From: Simon Davis <Simon.Davis@arun.gov.uk>
Sent: 26 November 2025 09:40
To: Planning.Responses <Planning.Responses@arun.gov.uk>
Subject: FW: Formal Objection to Planning Application AL/107/25/PL

From: Tom Bond [REDACTED]
Sent: 25 November 2025 20:29
To: Simon Davis <Simon.Davis@arun.gov.uk>
Subject: Formal Objection to Planning Application AL/107/25/PL

Please register this letter as my formal objection to the above planning application.

DRAWING TITLE  
 Proposed Elevations

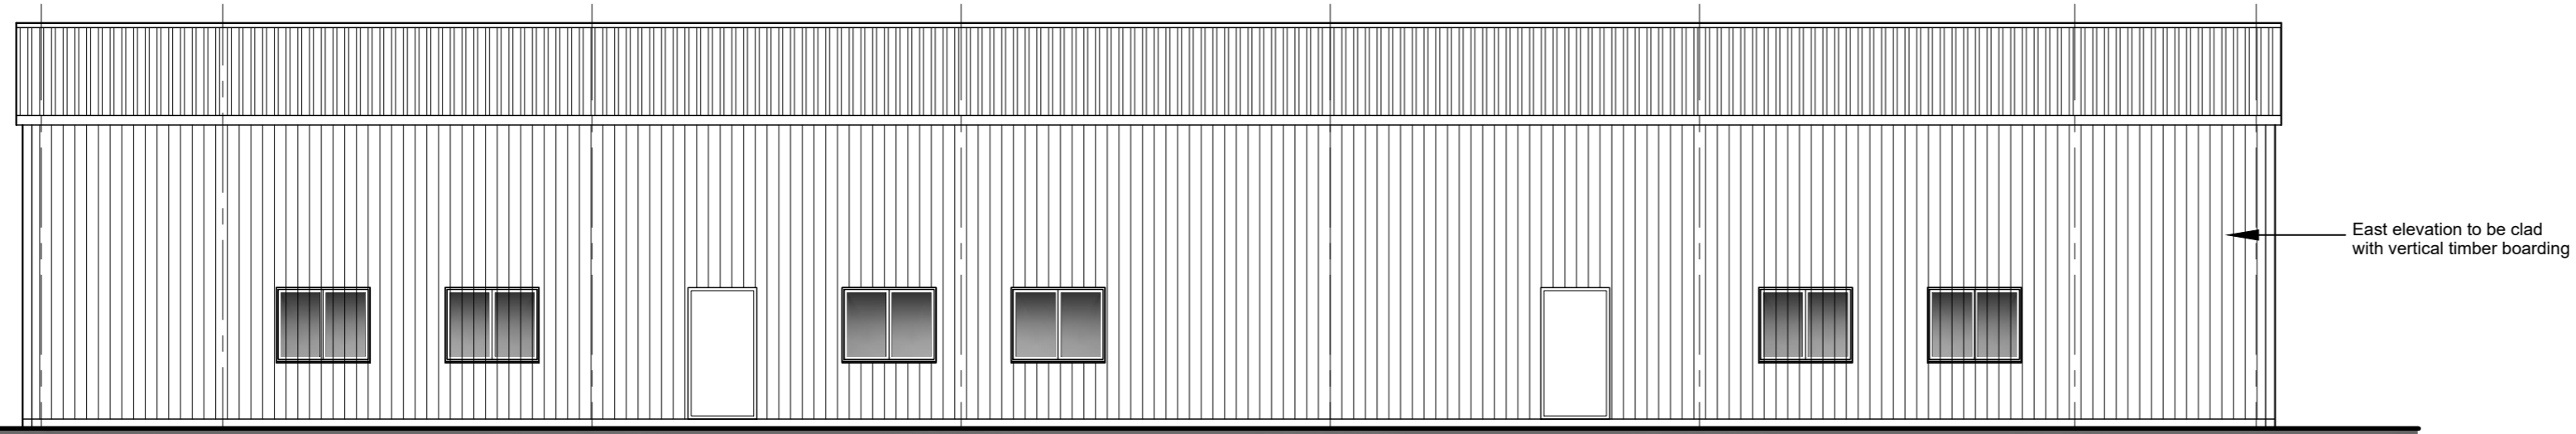
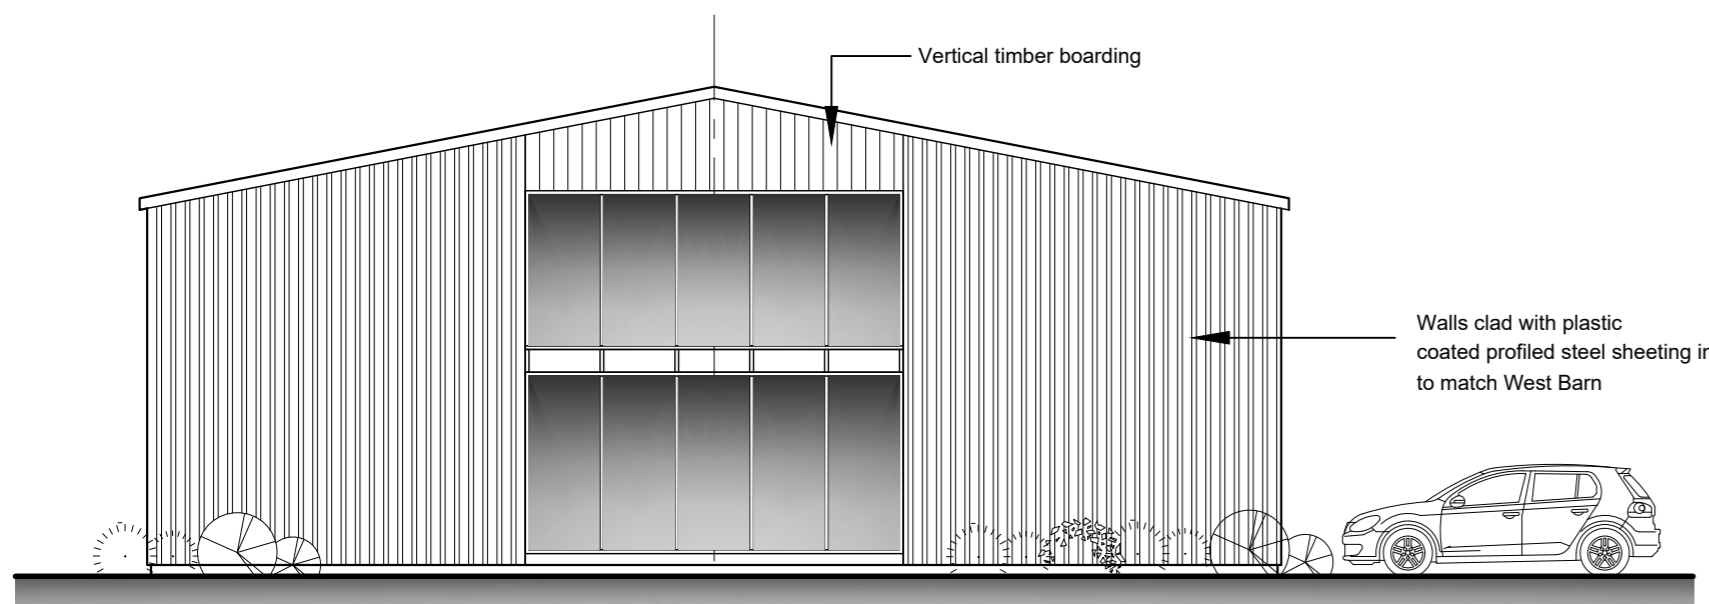
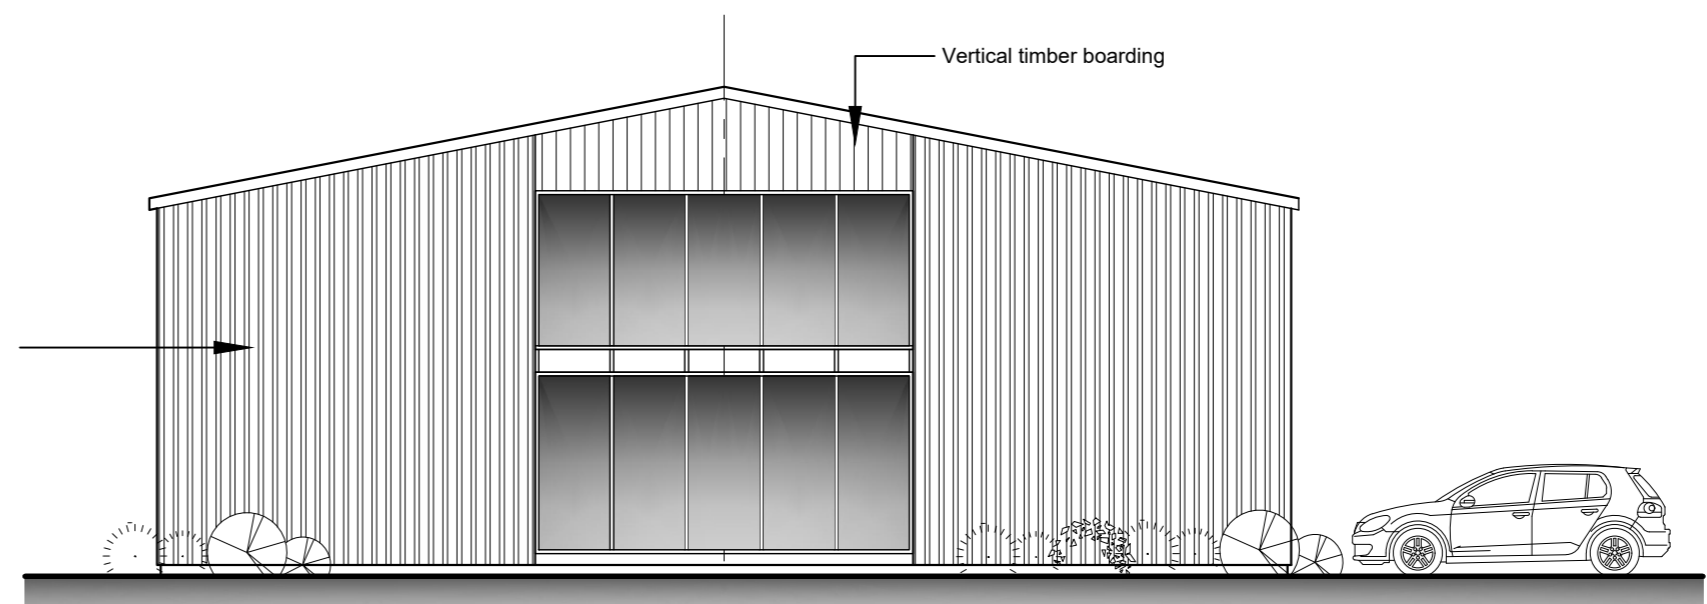
The proposed commercial building would be sited approximately 8 metres south of my property boundary (The Old Stables), which is a single-storey dwelling. At around 8 metres high, the building would directly overlook my home and private garden through full-height glazing on the southern elevation. This would cause:

- Severe **loss of privacy** and direct **overlooking** into the main living areas and garden.
- Significant **loss of light** and **overshadowing**, given its height and southern position, leaving my garden in shade for much of the day and year.
- An **overbearing and unneighbourly impact** completely out of keeping with this quiet rural Conservation Area.

The current West Barn (as shown in the enclosed photograph) demonstrates the intended design and height; this clearly illustrates the scale of intrusion the new structure would create only 8 metres from my boundary.

Block Plan

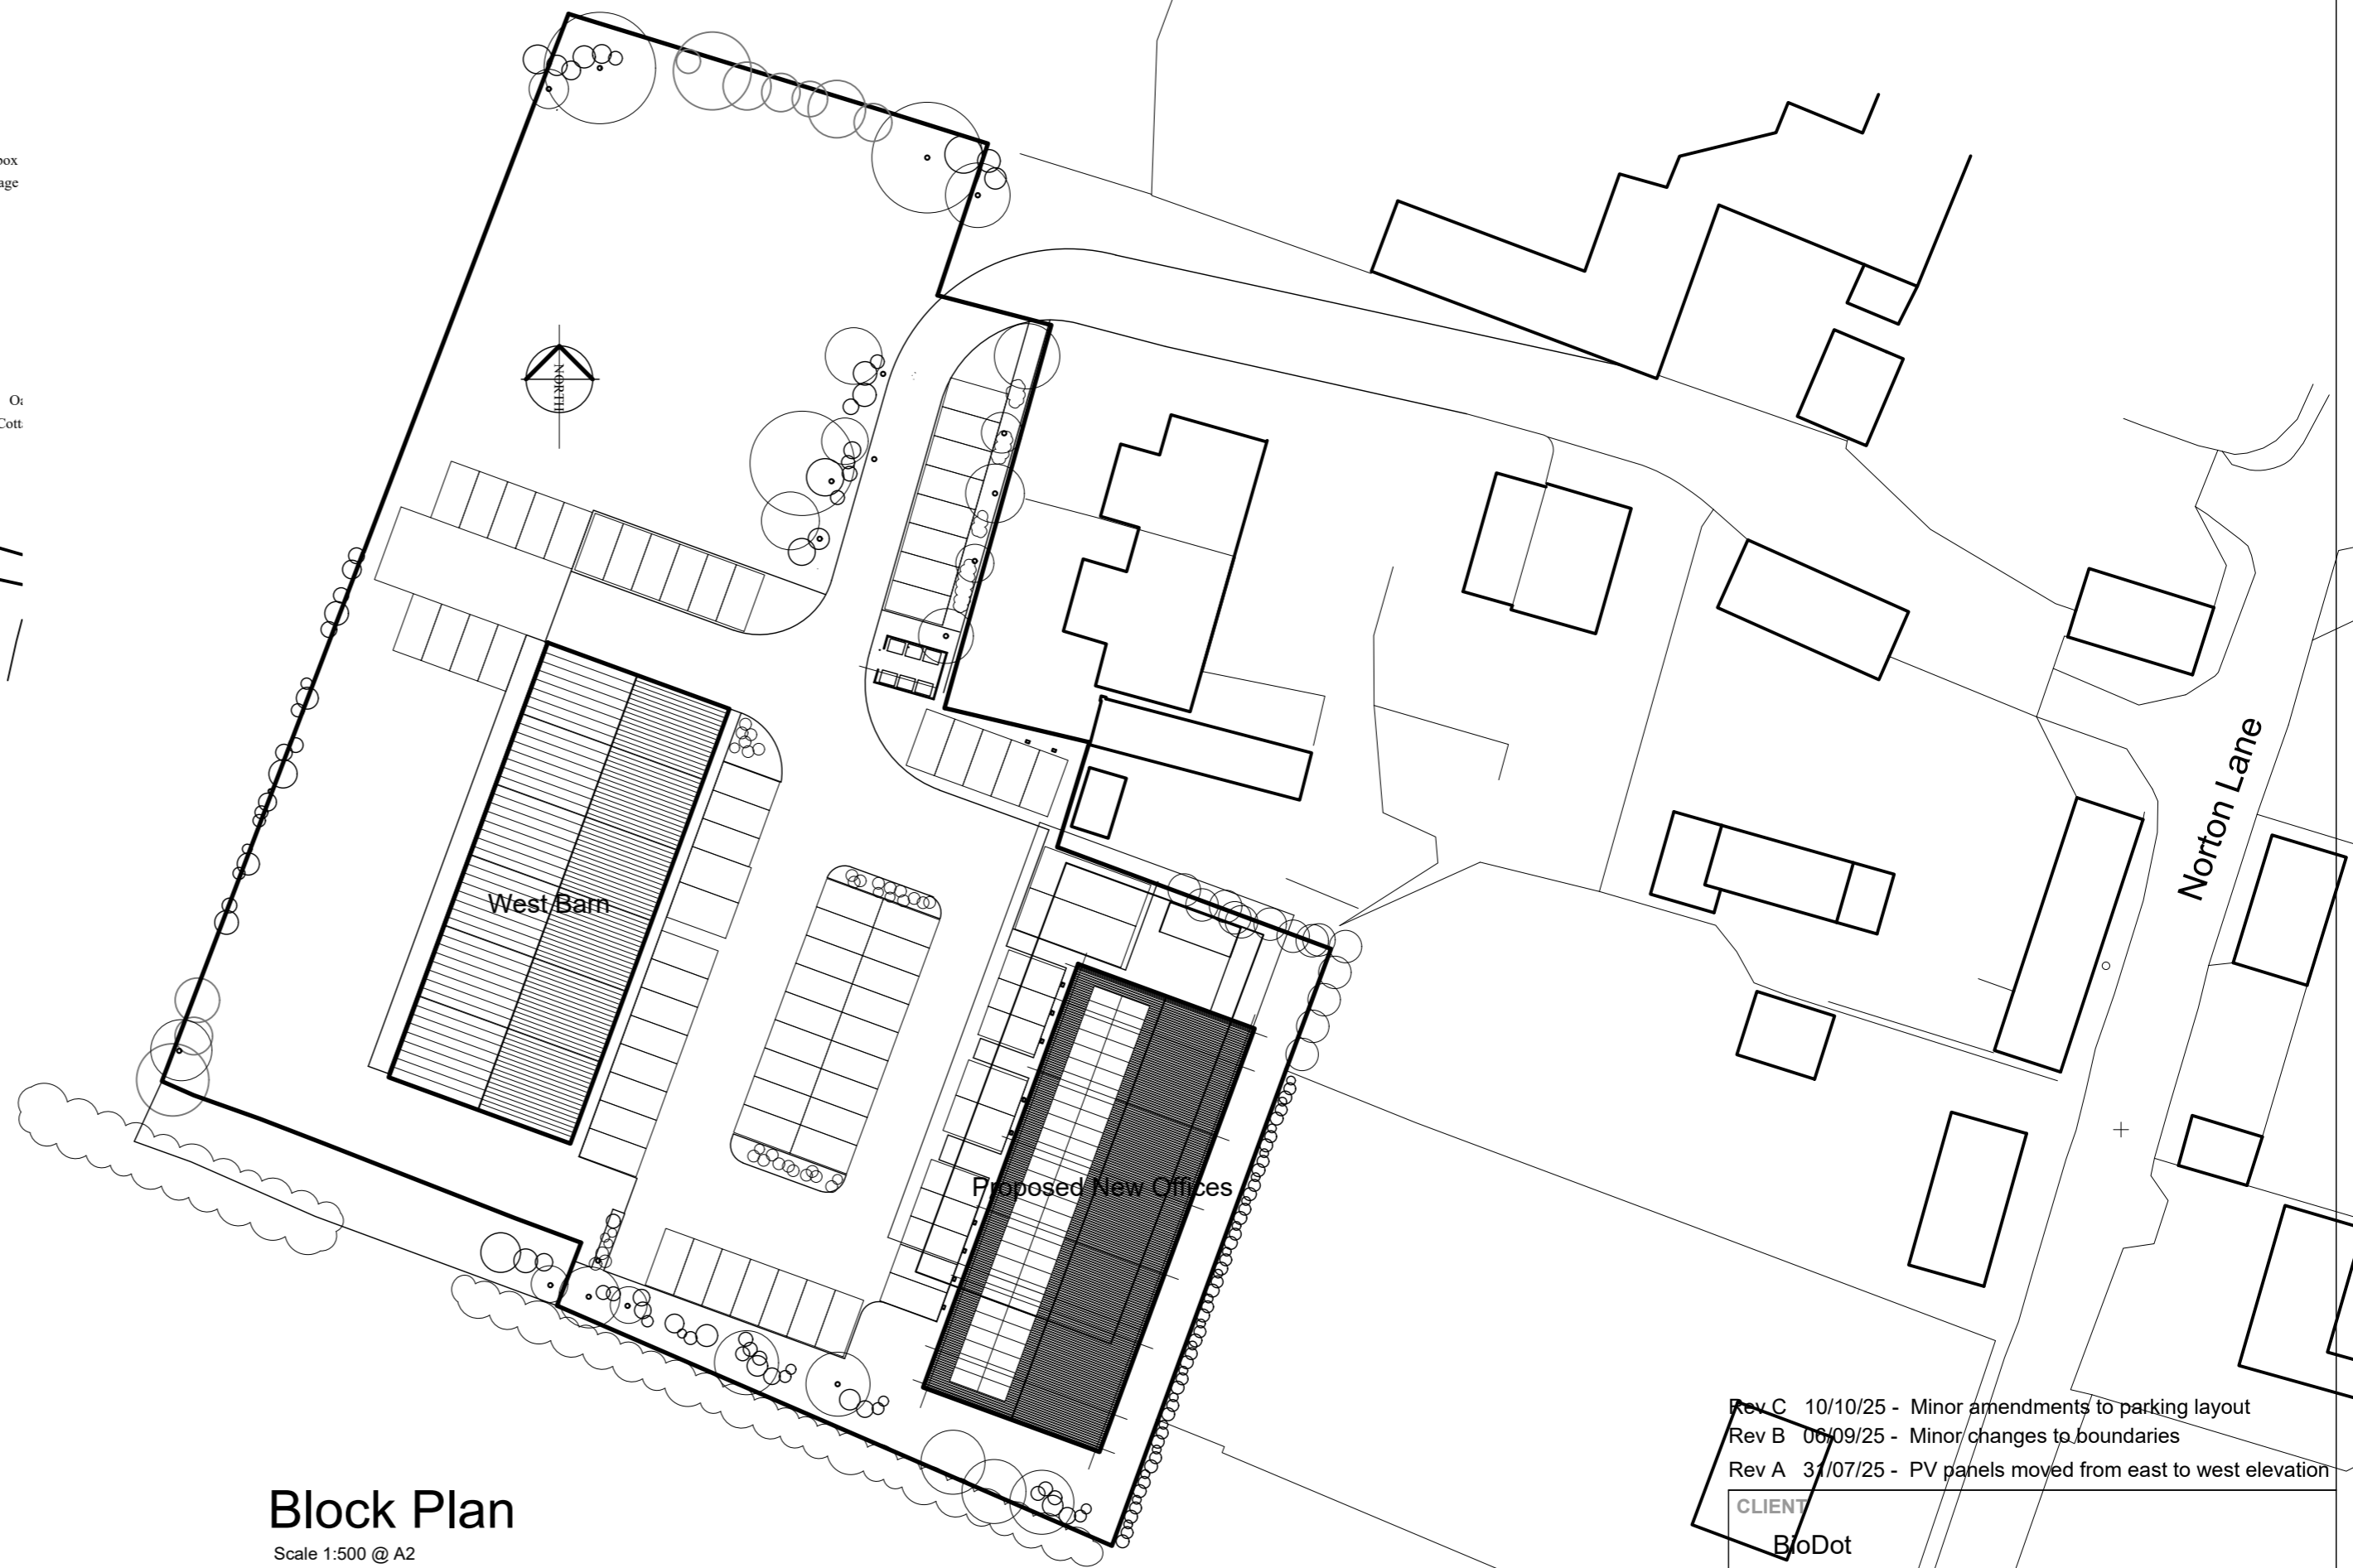
The proposed site layout places **LGV parking, cycle storage, and EV charging points** directly alongside my fence. This positioning will cause unacceptable and continuous disturbance:

- LGV drivers will be elevated and able to look directly into my garden.
- Vehicle engines, doors, radios, and conversations will cause noise nuisance.
- Cycle storage areas typically become gathering points for smokers and vapers, producing smoke and odour drifting over the fence.
- EV charging points present additional concerns—potential fire risk and continuous white-noise hum from chargers.

The proposal includes an extra 40 parking spaces (plus 2 LGV spaces), doubling existing capacity and creating unsustainable traffic levels for this constrained access.
